CHRIS TEAM SUBDIVISION

FINAL DRAINAGE REPORT

ALL TERRAIN ENGINEERING PROJECT NO: 24019

SF2426

## EXISTING CONDITIONS DRAINAGE MAP

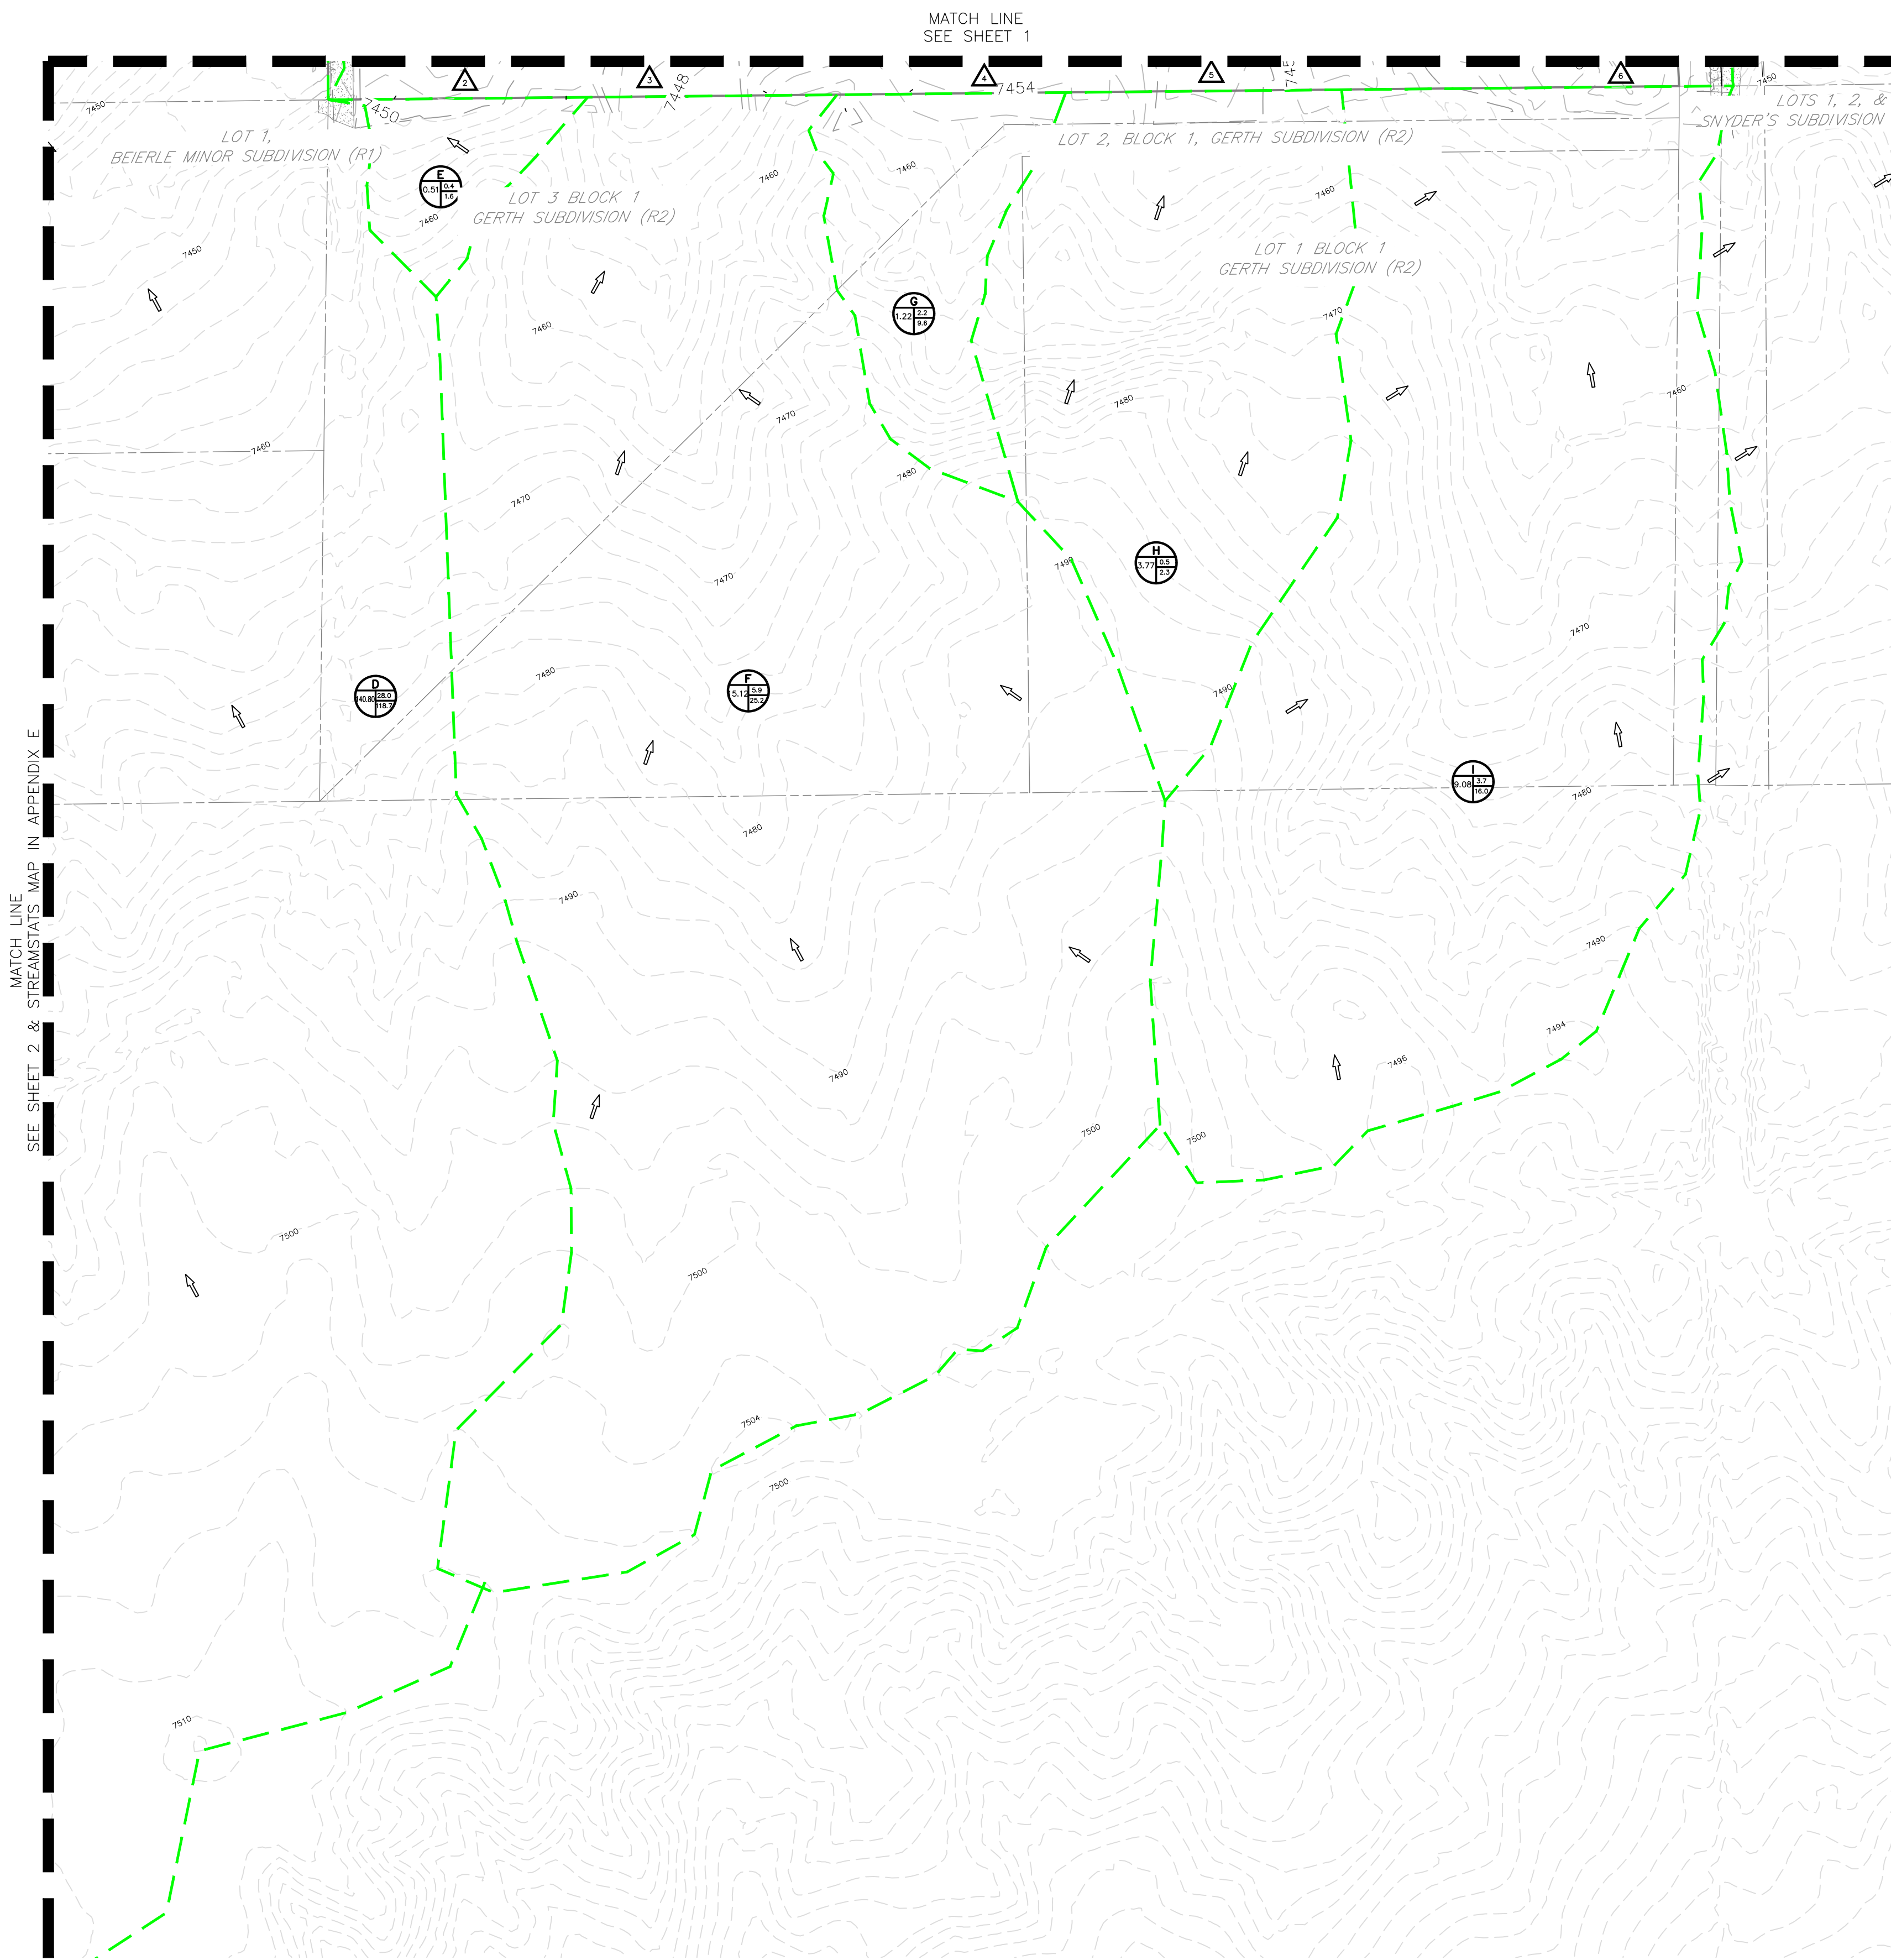
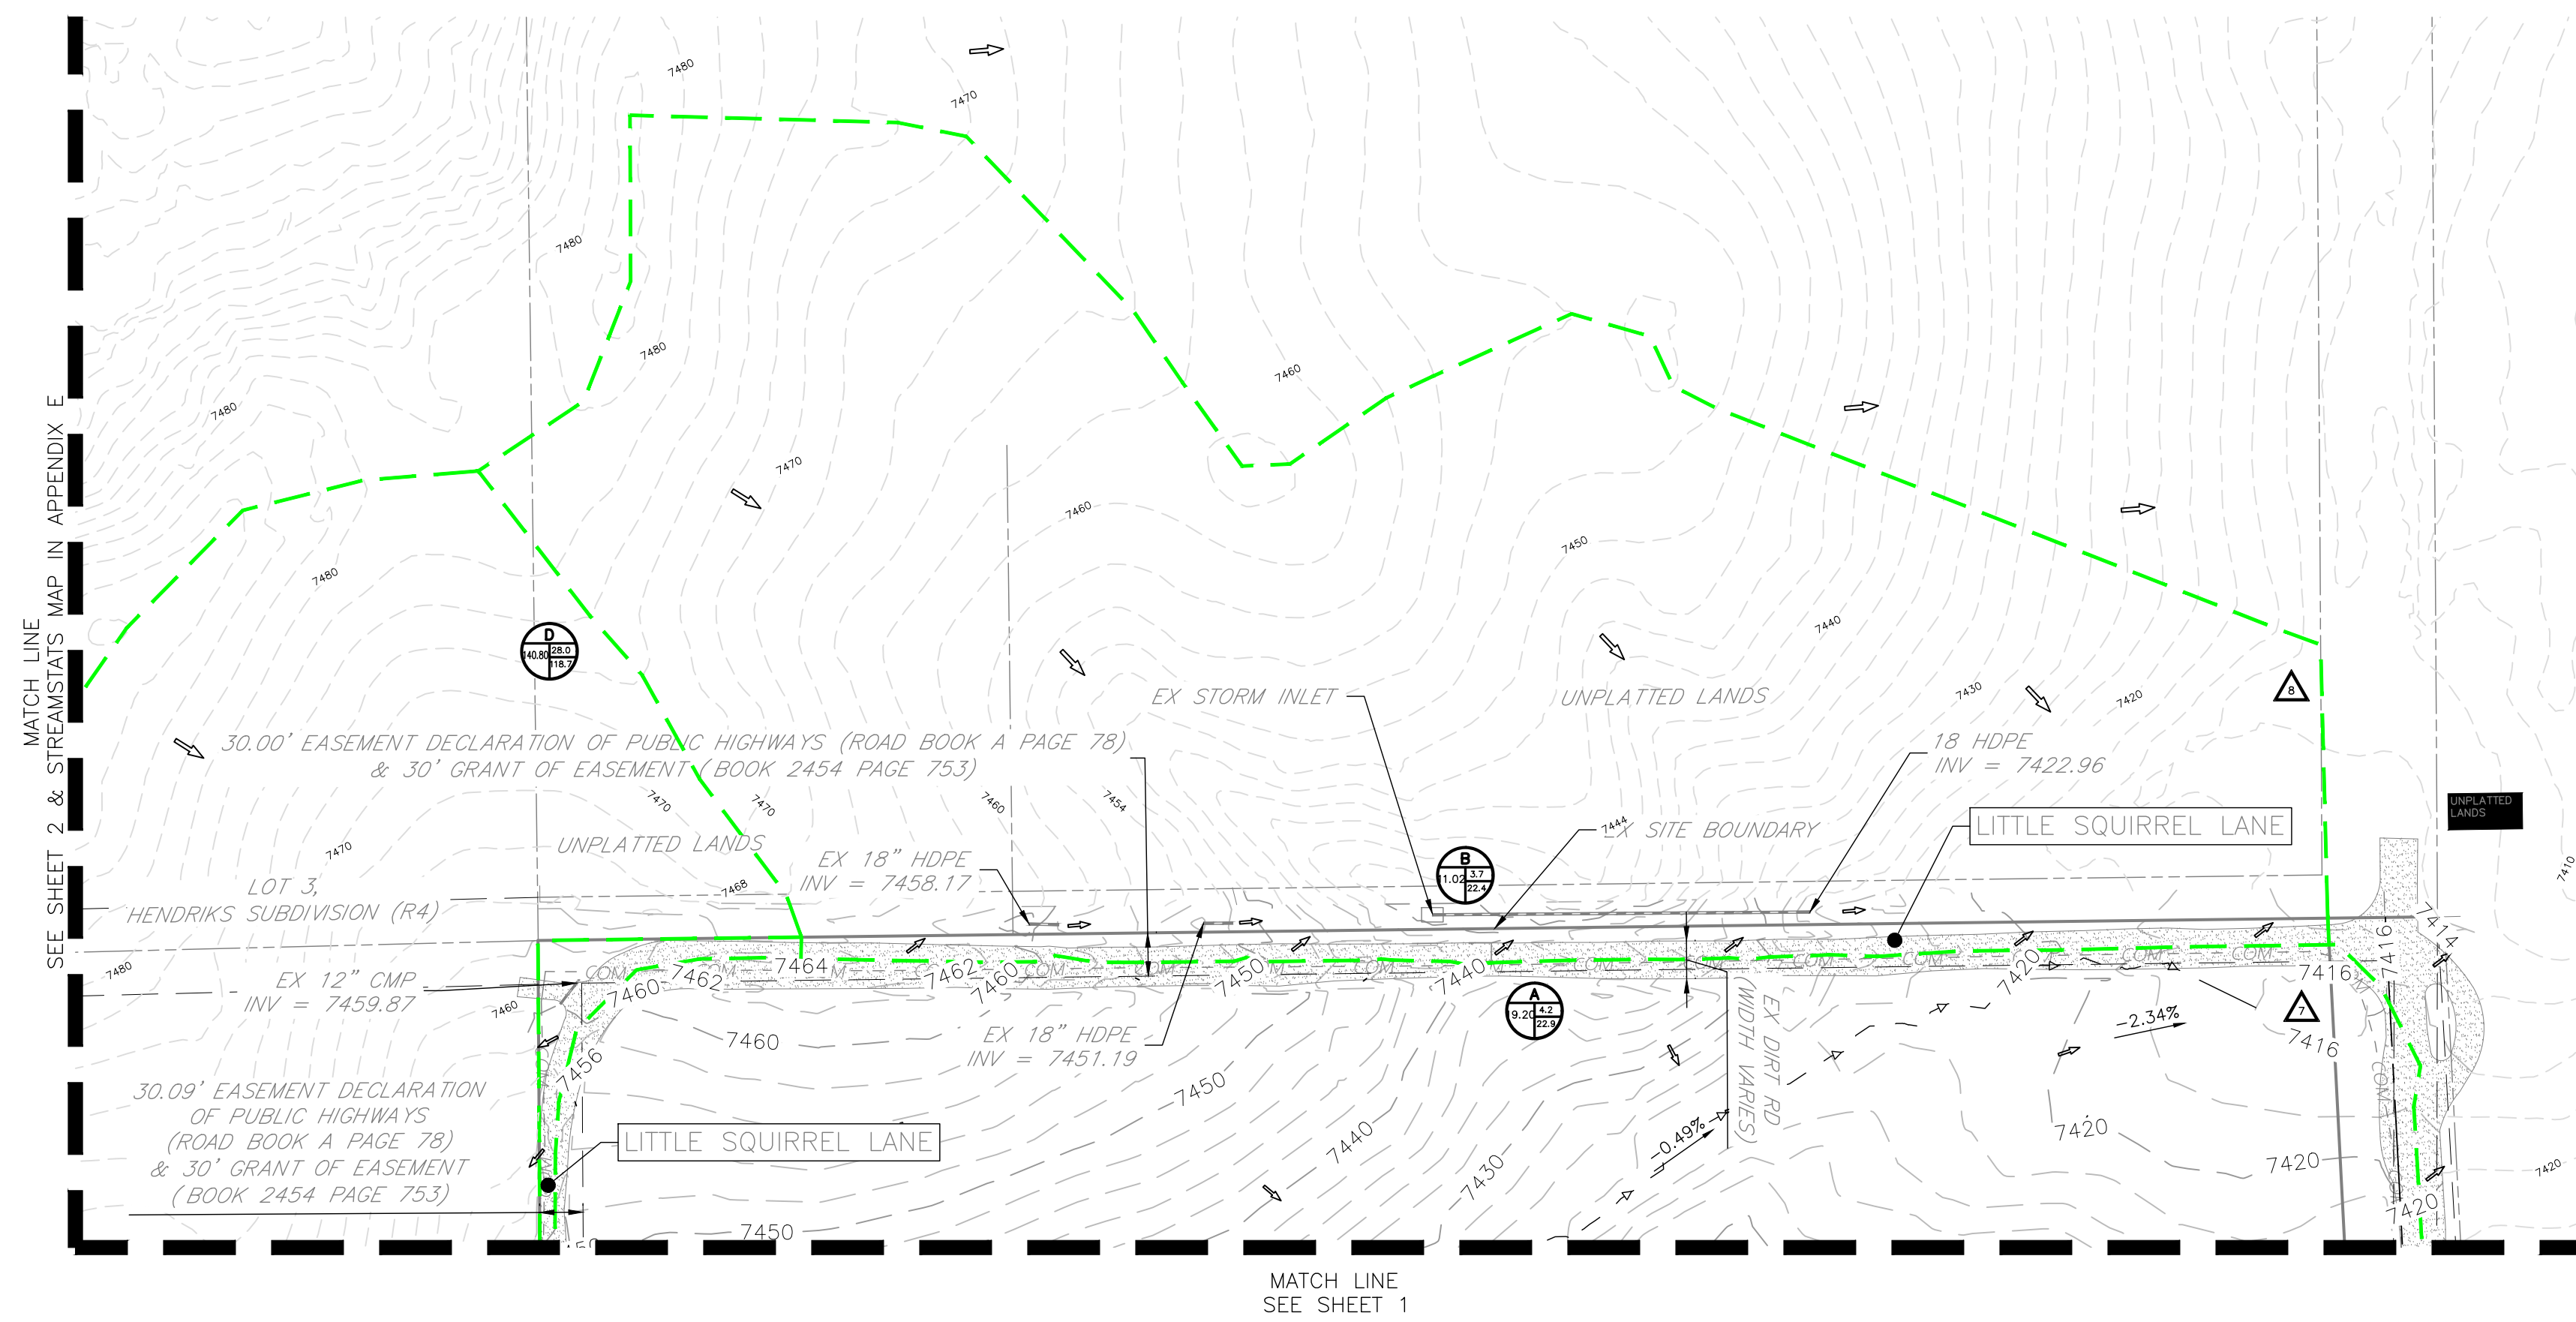
It appears that the analysis in the written narrative and maps/aerials is mixed between the Chris Team Subdivision property and parcel 5114006001 to the south. Based on aerials and site visit there is no existing driveway or structures on the applicant's property.

Include a discussion of the existing 12" culvert at the NW corner of the site, as shown on the drainage map
